Online Comment

Application H22-0398-18
Location Land off Small Drove Weston Spalding PE12 6HU
Proposal Residential development comprising 34 dwellings

Name Glen Chapman
Address Environmental Services South Holland District Council

GENERAL AMENDMENTS - ISSUED FOR PLANNING APPROVAL			
Rev	Revision note	Date	Drawn by
1	RESIDENTIAL DEVELOPMENT AT SMALL DROVE WESTON FOR WELAND HOMES	25.04.2018	PC
2	Drawn by PC	Checked	Date FEB 2018
3	Scale 1:2008A1	Dwg No J1651 (08) 03	Rev A

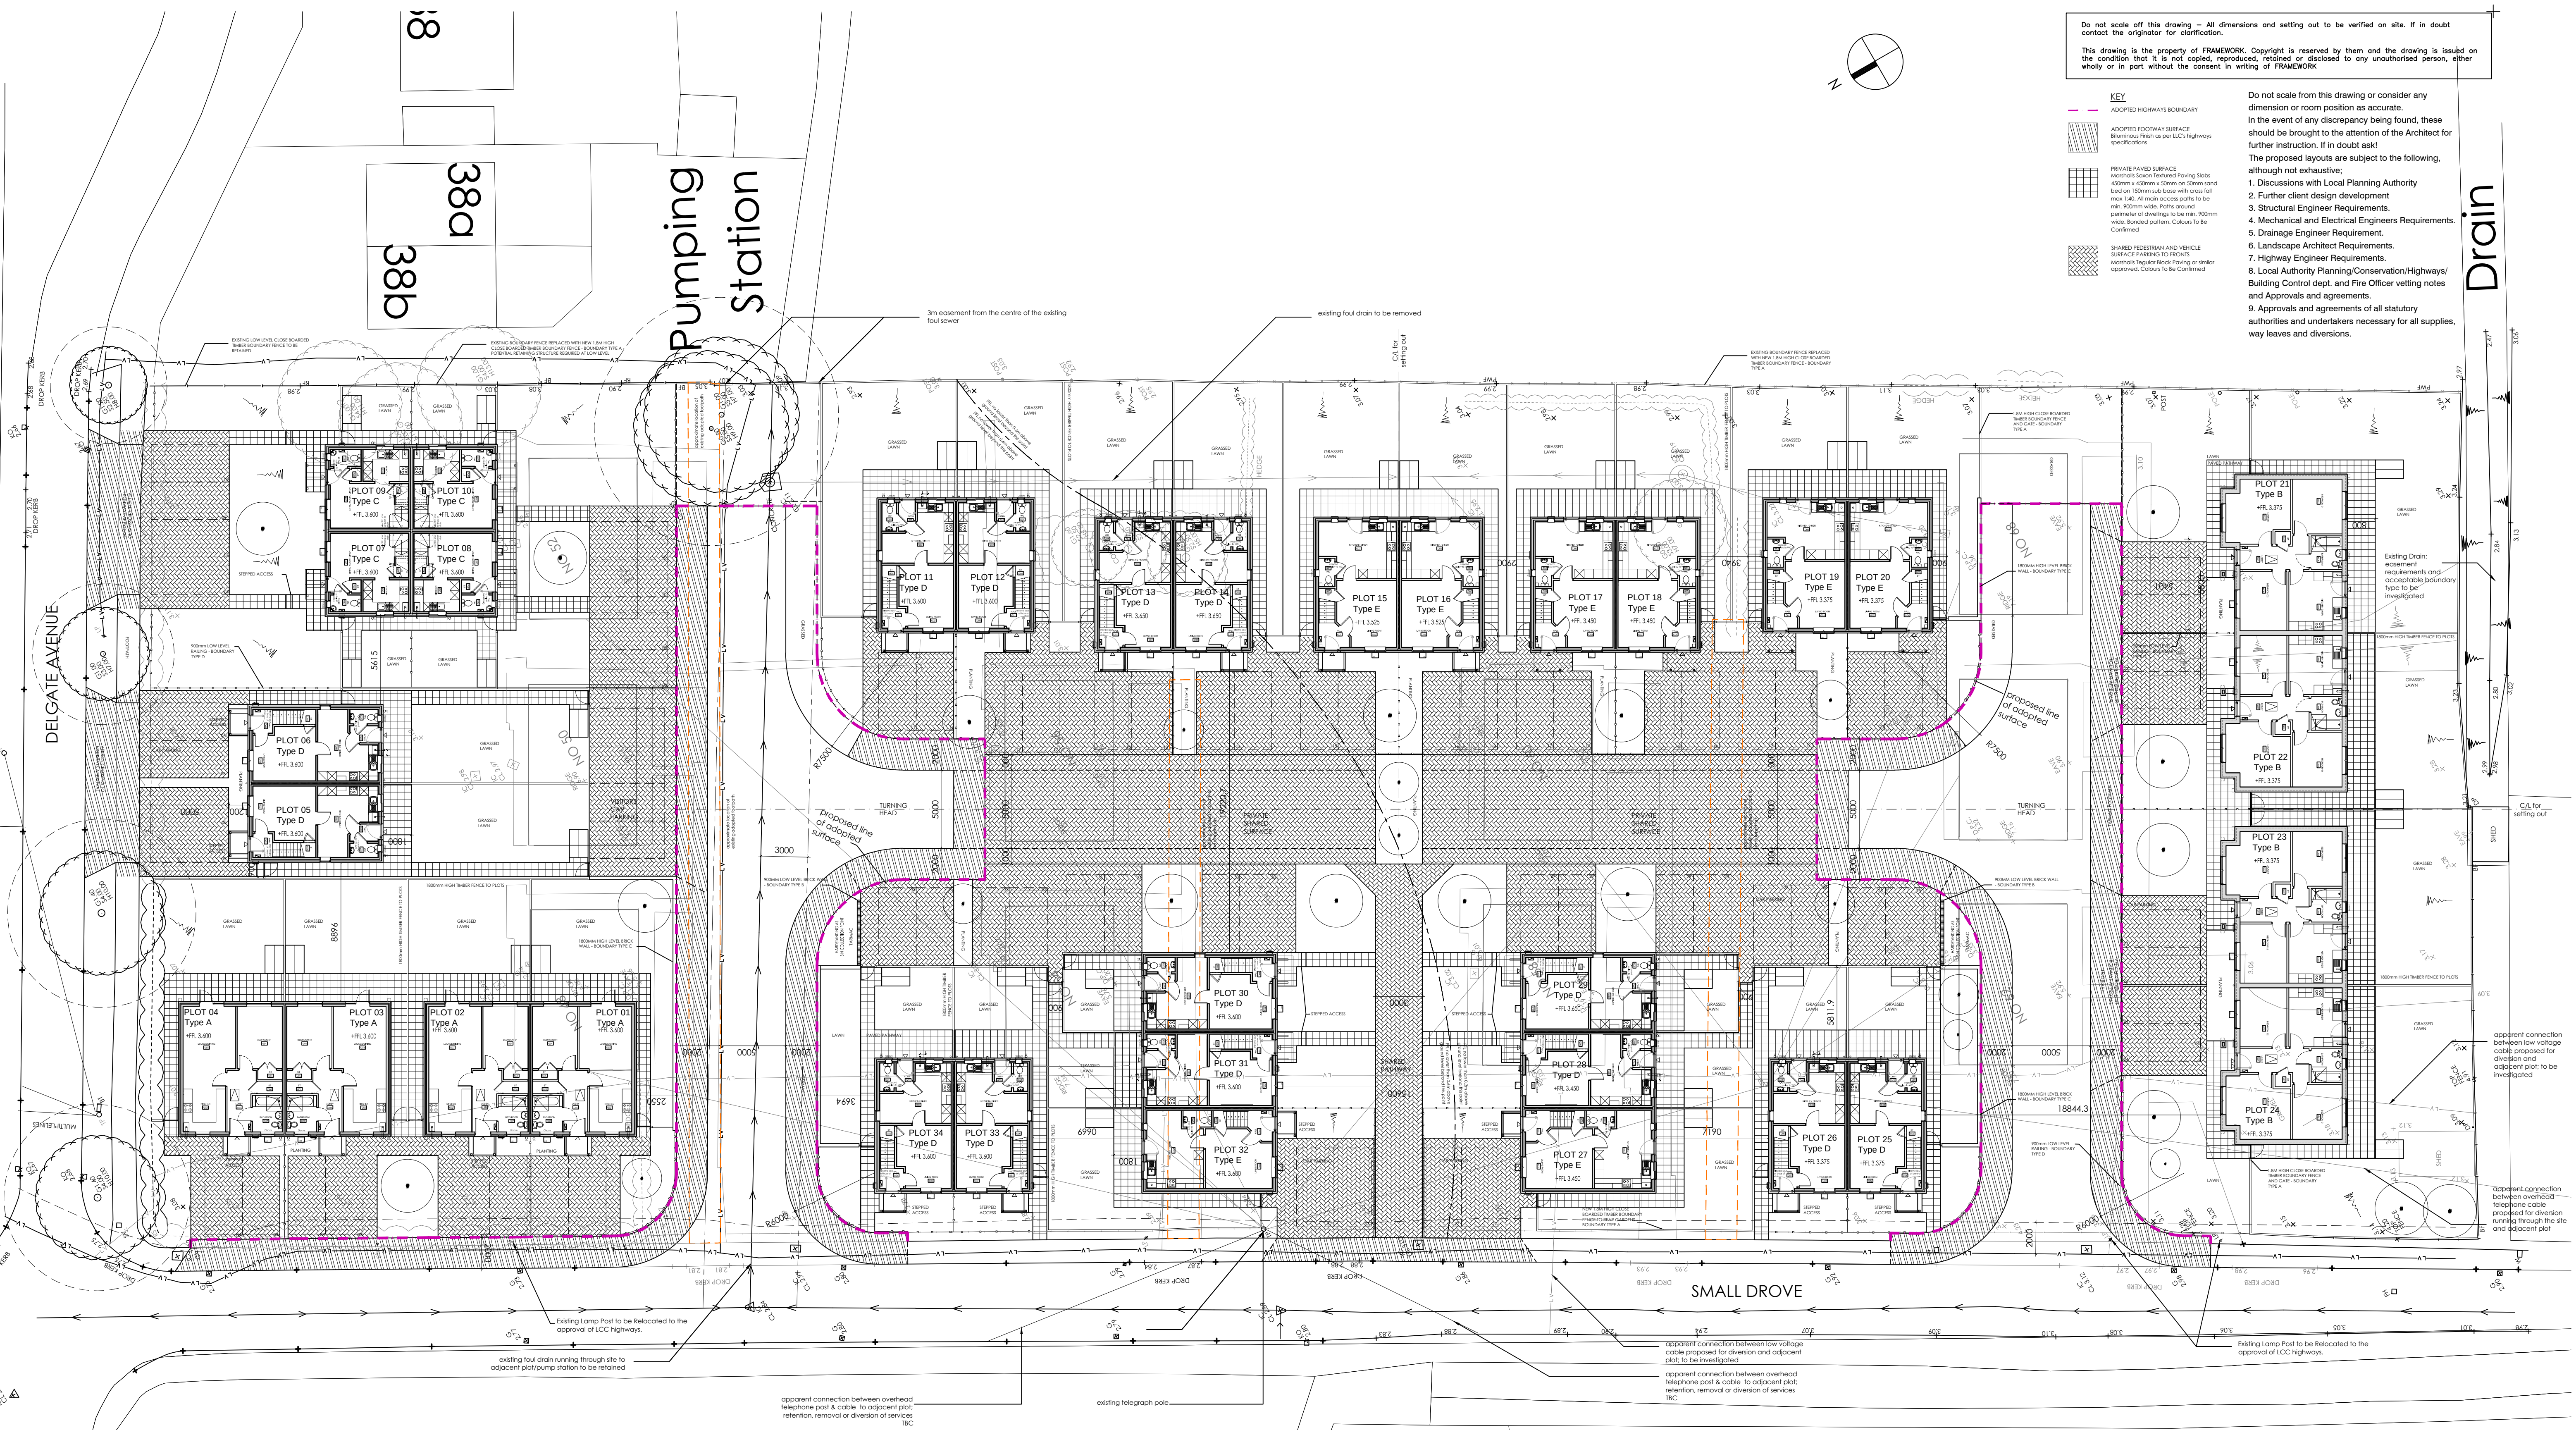
Access roadways to all residential properties should be constructed to an adoptable standard under an agreement with Lincolnshire County Council so that they will become public highways. This will enable refuse/recycling collections to be carried out from outside individual properties without the need for communal collection points at the point where private driveways adjoin public highways.

Should it be agreed that communal collection points will form part of this development the position of those collection points should be made clear to the potential occupiers of the properties nearby. This should not just be to the properties that will need to use the collection points but also the ones who will have them outside their properties.

Plots 13 - 18 and 28 - 31 will need to present their sacks to either of adopted access roads to be constructed off Small Drove.

Plots 11, 12, 19, 20, 25, 26, 33 and 34 will need informing that they are likely to have sacks from other properties of the development presented outside their property.
